From: [REDACTED]
Sent: 16 January 2018 13:59
To: Planning
Subject: WA/84/17/PL

Re: Fairmeads Farm - Demolition of existing structure & paddock & erection of farm building for the secure storage of farm machinery fertilizer hay & straw (resubmission following WA/63/16/PL)

Title Proposed Agricultural building for secure storage of farm machinery, hay and straw at Fairmead Farm Binsted lane Binsted Arundel BN18 0LQ		Client Deborah Osborne Blackmill Cottage Blackmill Lane Norton Chichester West Sussex PO18 0JU
Scale 1:500	Date 27/11/17	Draw No RA/674/500 .IC Block plan

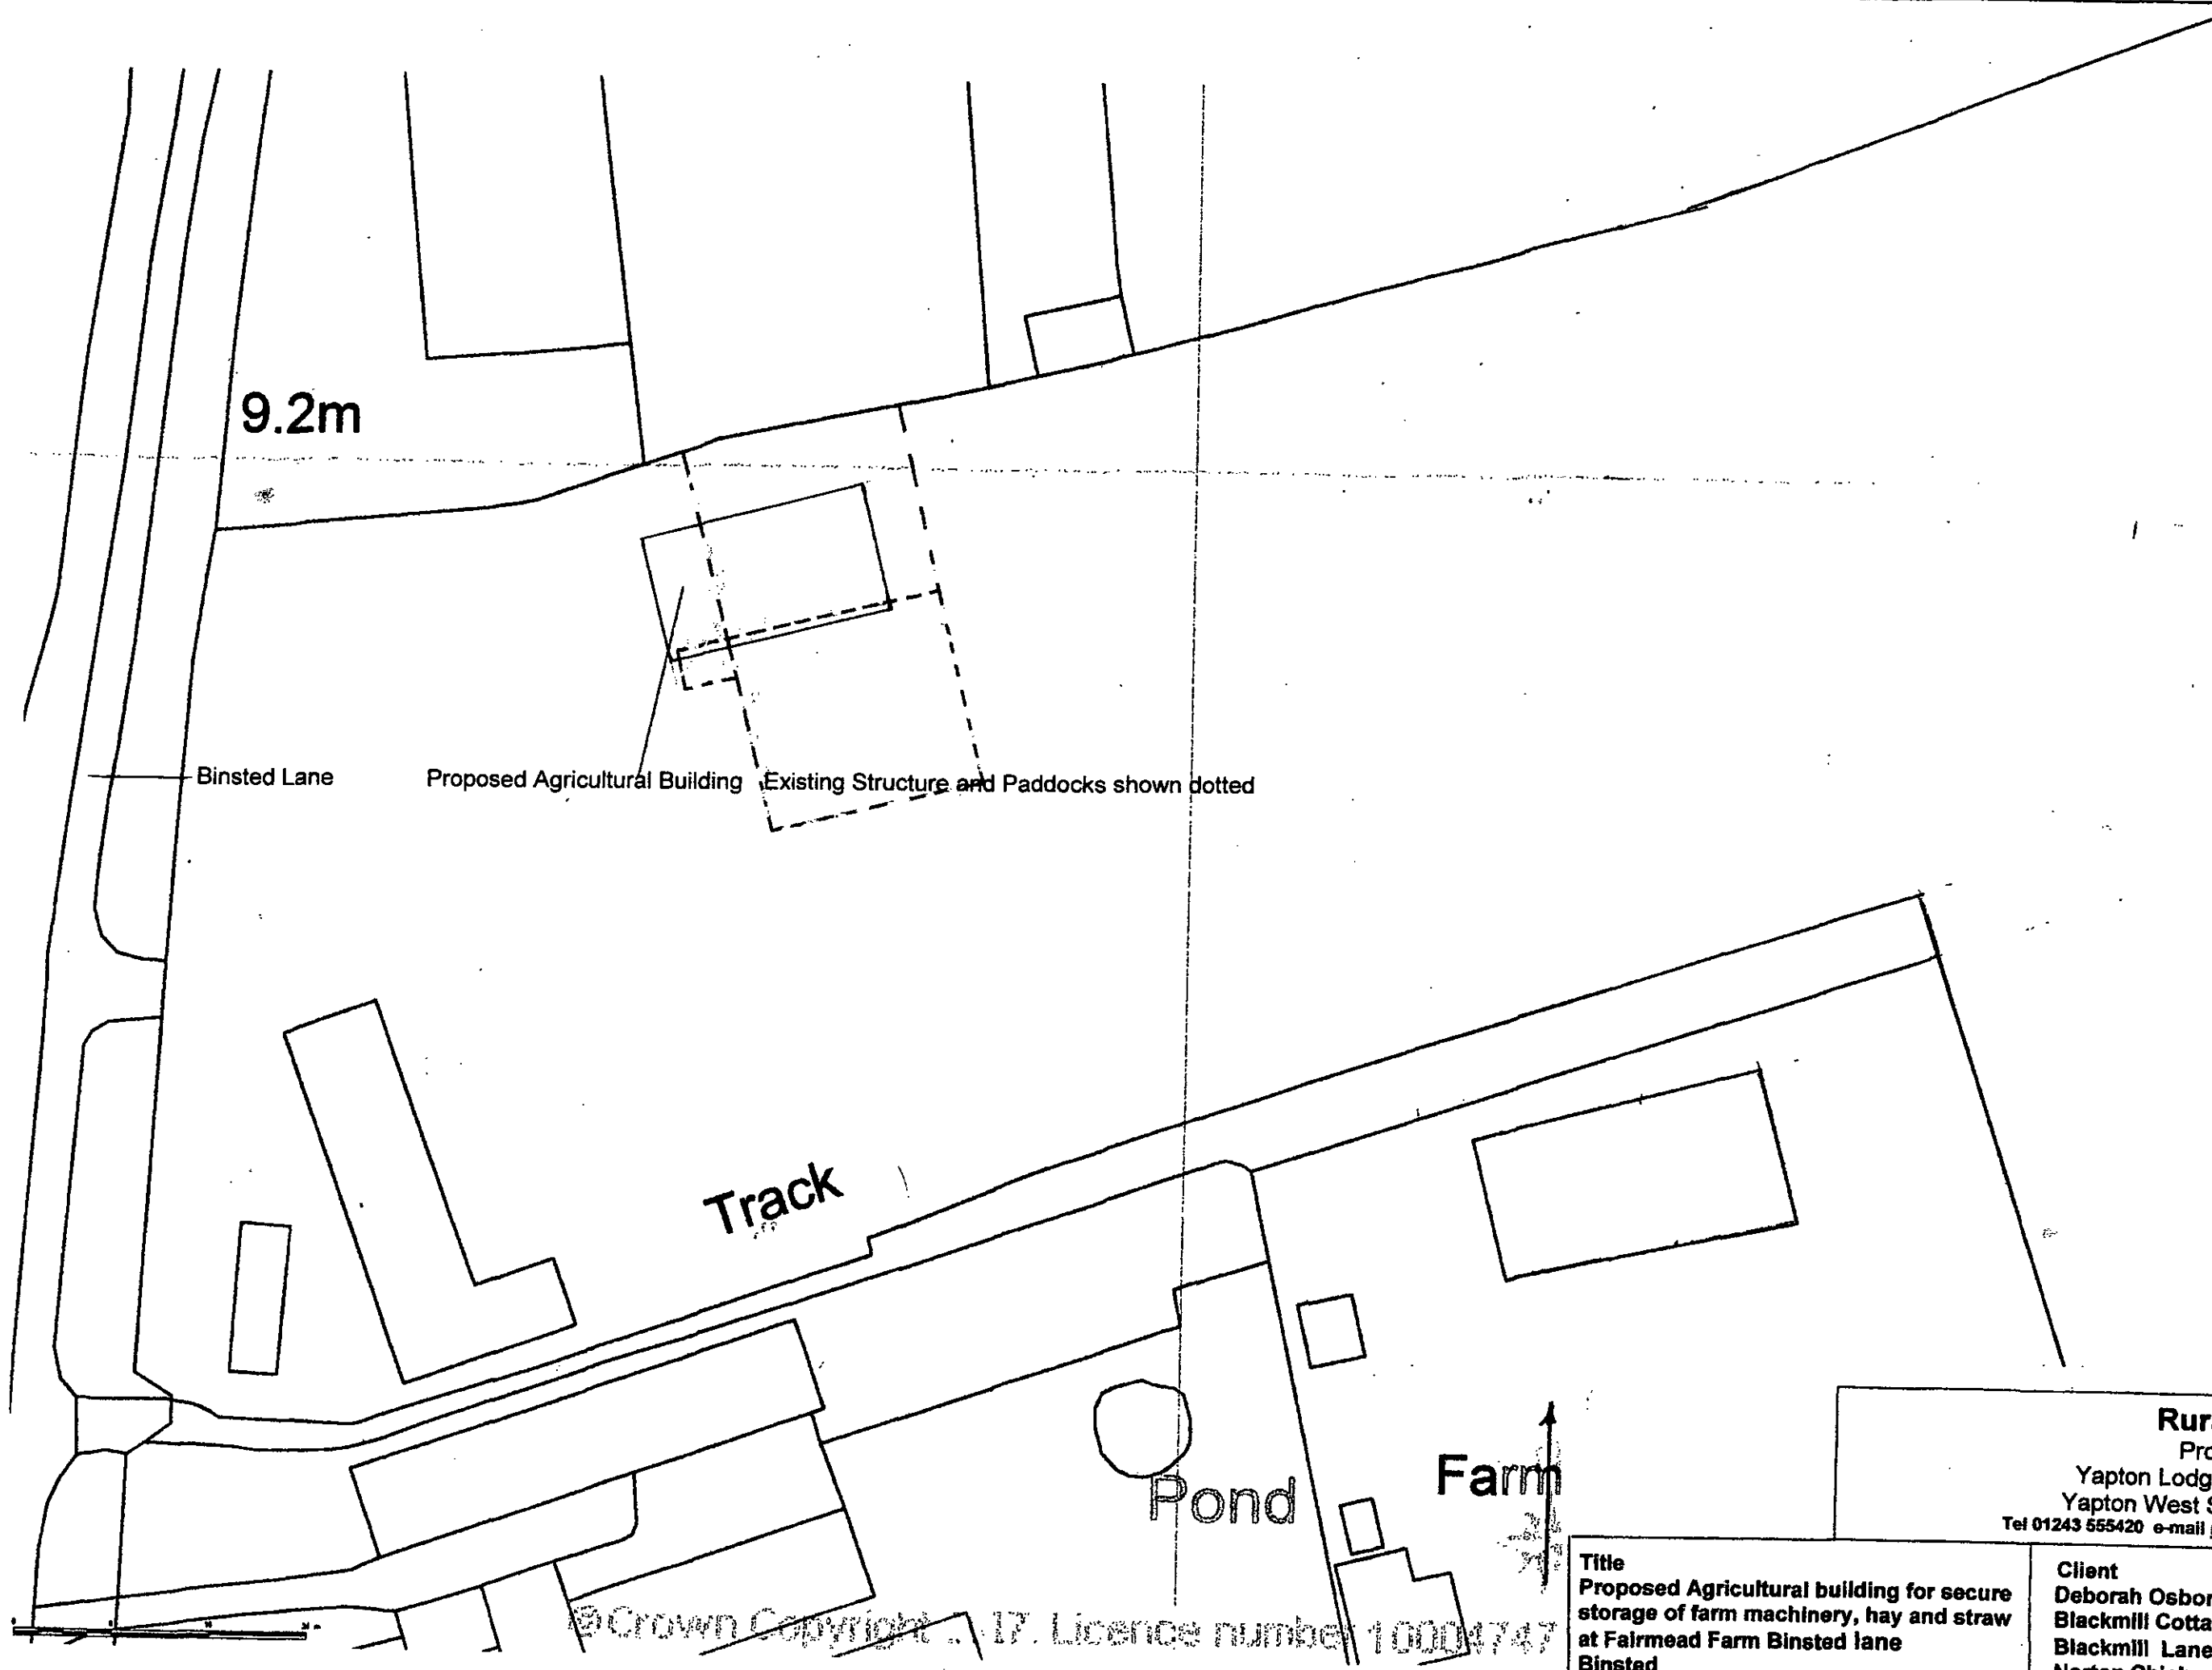
Curiously the only indication given of the definition of " existing structure " to be demolished is found in Block Plan RA/671/500 where it is stated to be shown " dotted ". The small 20m² shed can be seen protruding from the much larger area shown dotted on that plan which is not a structure at all. It is just part of the pasture/scrub site which the applicant strangely describes as " paddock ". The casual reader of that block plan could easily be misled into believing that a significant structure exists there which is certainly not the case. There's just a 20m² shed. If the planning officer is in any doubt a site inspection will clarify.
